## DEVELOPMENT FACILITATION TEAM

### Parks and Recreation Department

#### **PR-2019-002134**

SI-2024-00716 – SITE PLAN DFT

1 SITE PLAN
1" = 30'-0"

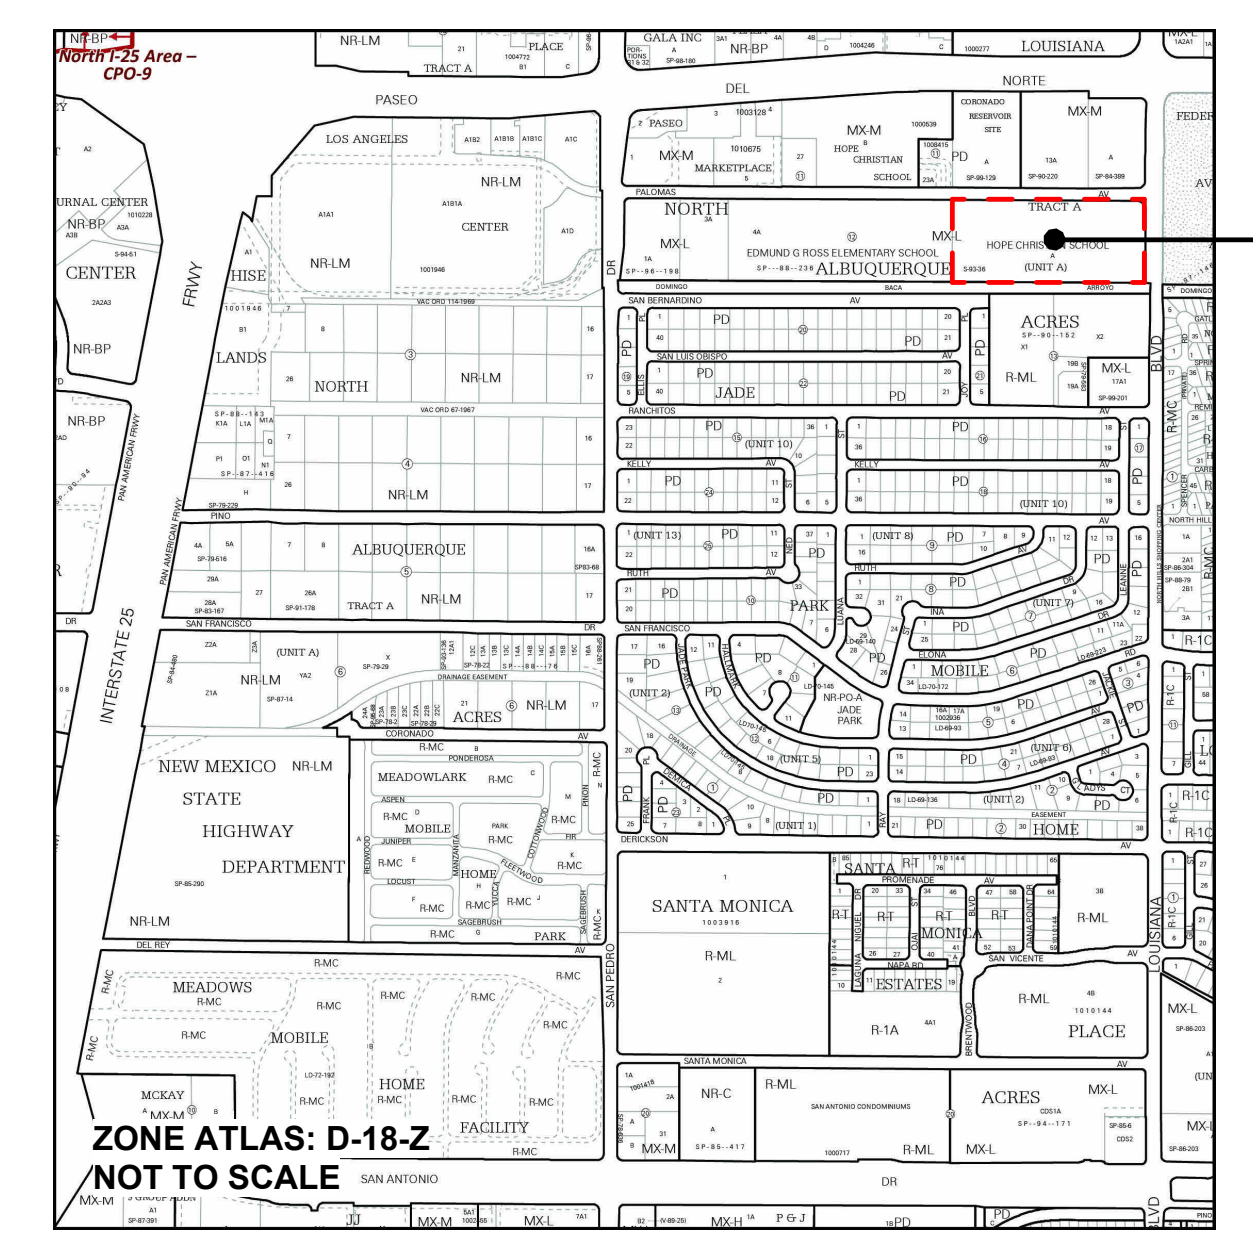
Please verify that these standards regarding ground-mounted mechanical equipment, outdoor loading, service and refuse areas, and walls/fences have been addressed with this site plan submittal. All standards for visibility and adjacency to City trail or public trail will apply if included in the site design.

**Applicant Response:** To the best of our knowledge, the standards referenced regarding screening of ground-mounted mechanical equipment, outdoor loading, service and refuse areas, and walls/fences have all been addressed in our Site Plan submittal. Please see note on Site Plan AS.100 describing how a vegetated fence per IDO 5-6(F)(3)(a) will be used to screen the south/east parking lots, as well as a nearby ground-mounted electrical transformer, from view of Domingo Baca Arroyo. Please also see landscape plans LP.101 and LP.102 for specification of the vines that will be used to achieve the required 75% minimum vegetative screening opacity. The proposed outdoor kitchen loading space and outdoor refuse area will also be screened by this fence. The refuse area itself will be located within an enclosure per IDO 5-6(G)(3)(e).
